Table 2: Examining authority’s general questions arising from the draft Development Consent Order (DCO) ([planninginspectorate.gov.uk](http://planninginspectorate.gov.uk))

Question No.	To	Question	LCC Response
<b>1. General and Cross-topic Questions</b>			
1.1.1	All Parties	<p><b>Revised Energy National Policy Statements</b></p> <p>On November 22nd the Department for Energy Security and Net Zero published an updated version of the draft National Policy Statements (NPS) (EN1-5) (<a href="http://www.gov.uk">National Policy Statements for energy infrastructure - GOV.UK (www.gov.uk)</a>) which contain some changes to elements, particularly in the Overarching Statement EN-1, regarding the decision-making process for low carbon generation applications in general and including solar generating stations and related connections. These revised draft Statements have also been laid before parliament but are yet designated for the purposes of s104 of the Planning Act 2008.</p> <p>The ExA notes the Applicant intention to provide an updated Planning Statement to Deadline 2 to address the Revised Energy National Policy Statements issued. Do any parties other have any comments on the potential eff

Figure 6.1 Abnormal Load Movements

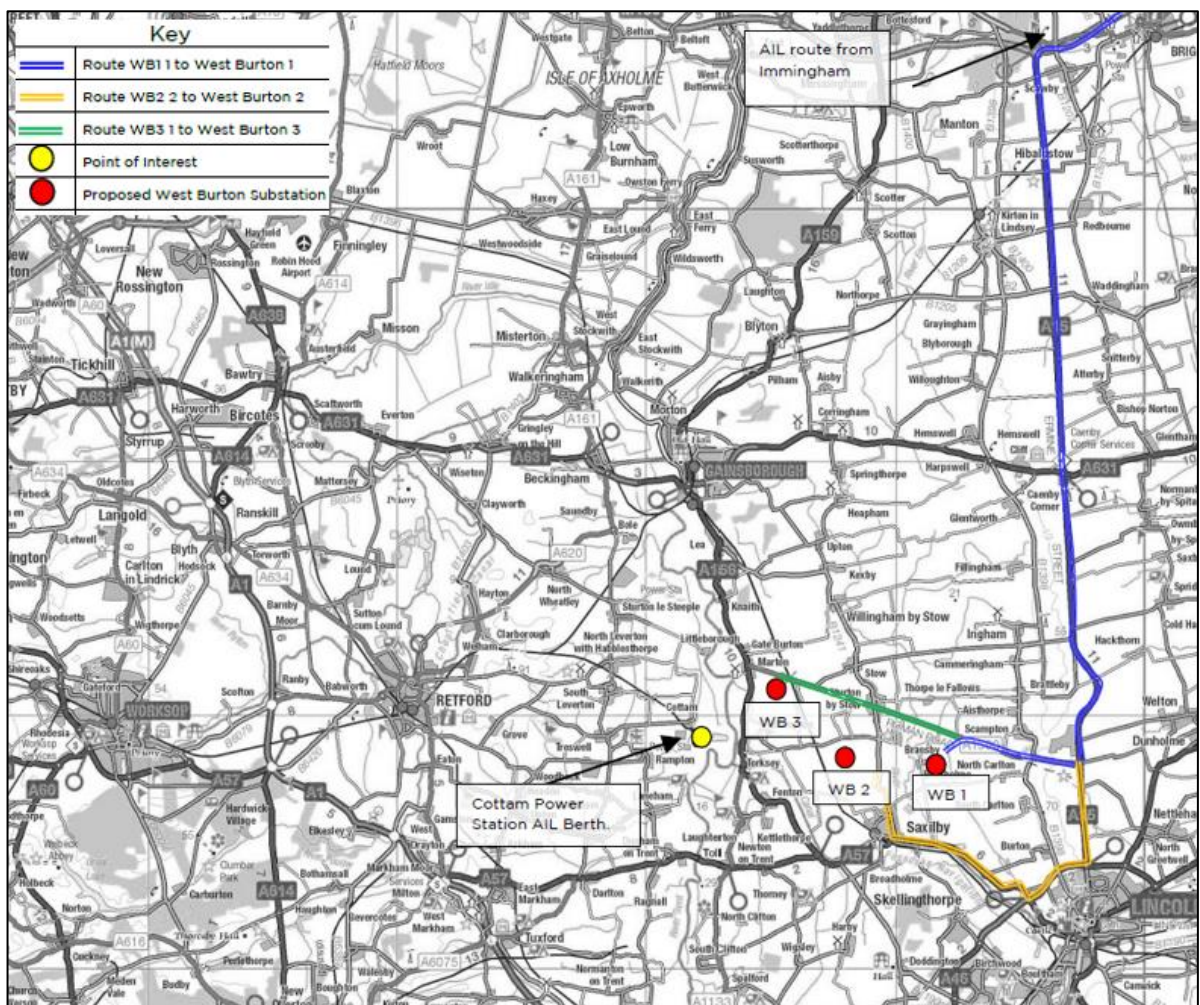
1.14.3	LCC	<p><b>Abnormal Loads</b></p> <p>a) Are NCC and LCC as satisfied with the arrangements for abnormal loads set out in the CTMP [APP-127], updated in [REP1-016] Appendix 14.2 Construction Traffic Management Plan Revision A.</p> <p>b) If not, please identify where issues arise and the reasons?</p>	<p>In principle the AIL assessment is acceptable at this stage. Approval from LCC's Abnormal Load Officer (and other parties) will be required prior to implementation .</p>
